From: Planning
Sent: 26 July 2021 14:30
To: Planning
Subject: R&U Planning Application Comments - 3/2021/0660

Planning Application Reference Number: 3/2021/0660

Your Comments: Whilst I accept that this project needs to proceed to ensure future water suppliers, I strongly object to the proposal to route heavy traffic through Chatburn, Grindleton and West Bradford, when a viable alternative has been suggested.

Grindleton Bridge - Chatburn (TA Link Refs. 71, 123 + 122)

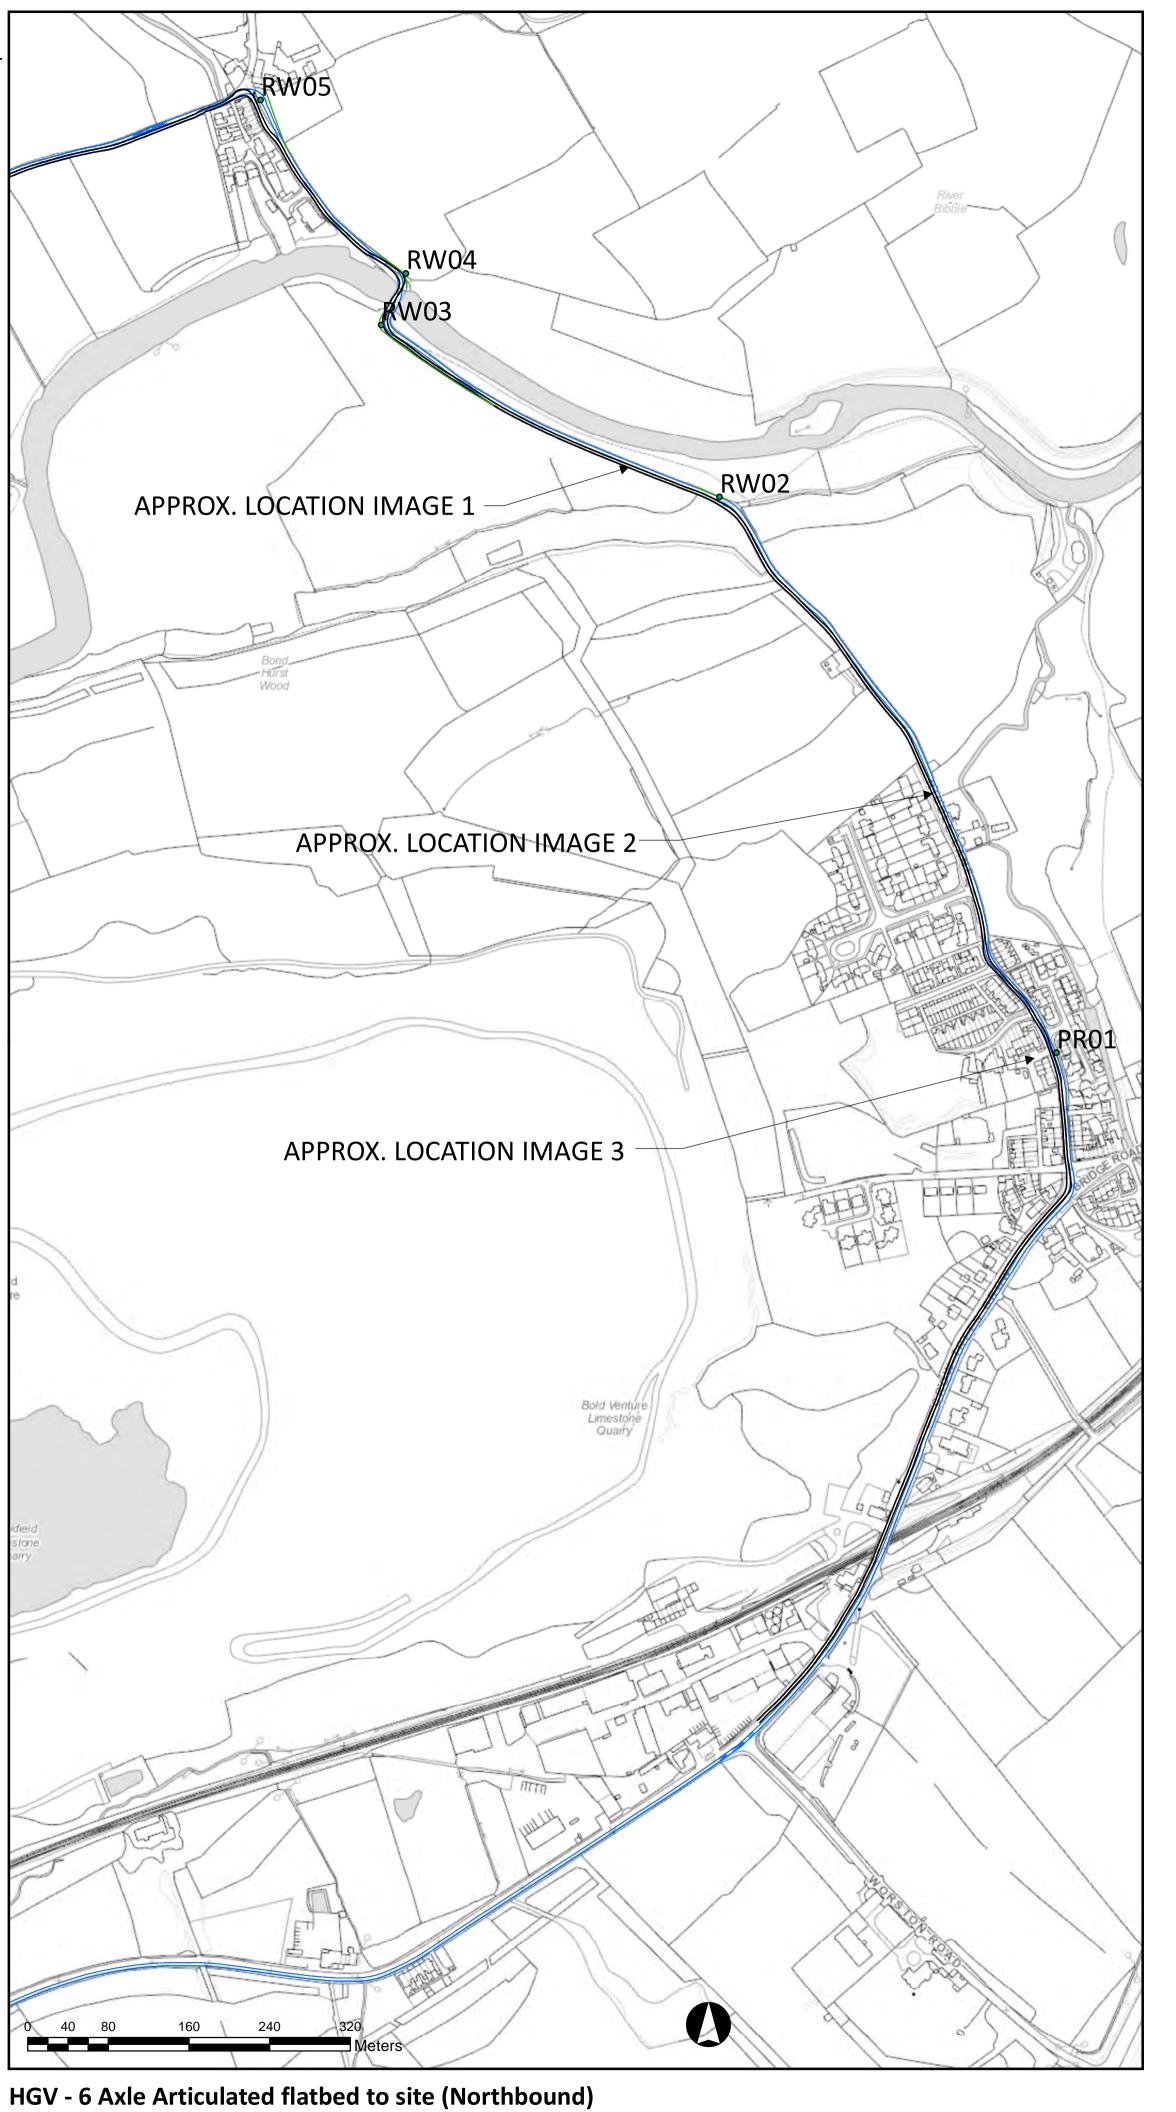
The Ribble crossing proposal would prevent six plus years of problems in these villages, including; Parking, on road parking would become impossible in Ribble Lane, Chatburn and East View, Grindleton. It is already

difficult at school times with coaches etc. Would there be long term provision for off road parking at these two locations?

Road Widening, the plans show widening before and after Grindleton bridge to allow vehicles to get enough angle to cross, if the original route is not fully re-instated afterwards this will then become a regular crossing for heavy vehicles.

Existing road structures, are Grindleton bridge and all the other culverts and bridges along this route able to take the increase load. I understand that the temporary traffic lights at West Bradford school are because of a collapsing culvert, this has taken 18 months to start repairs.
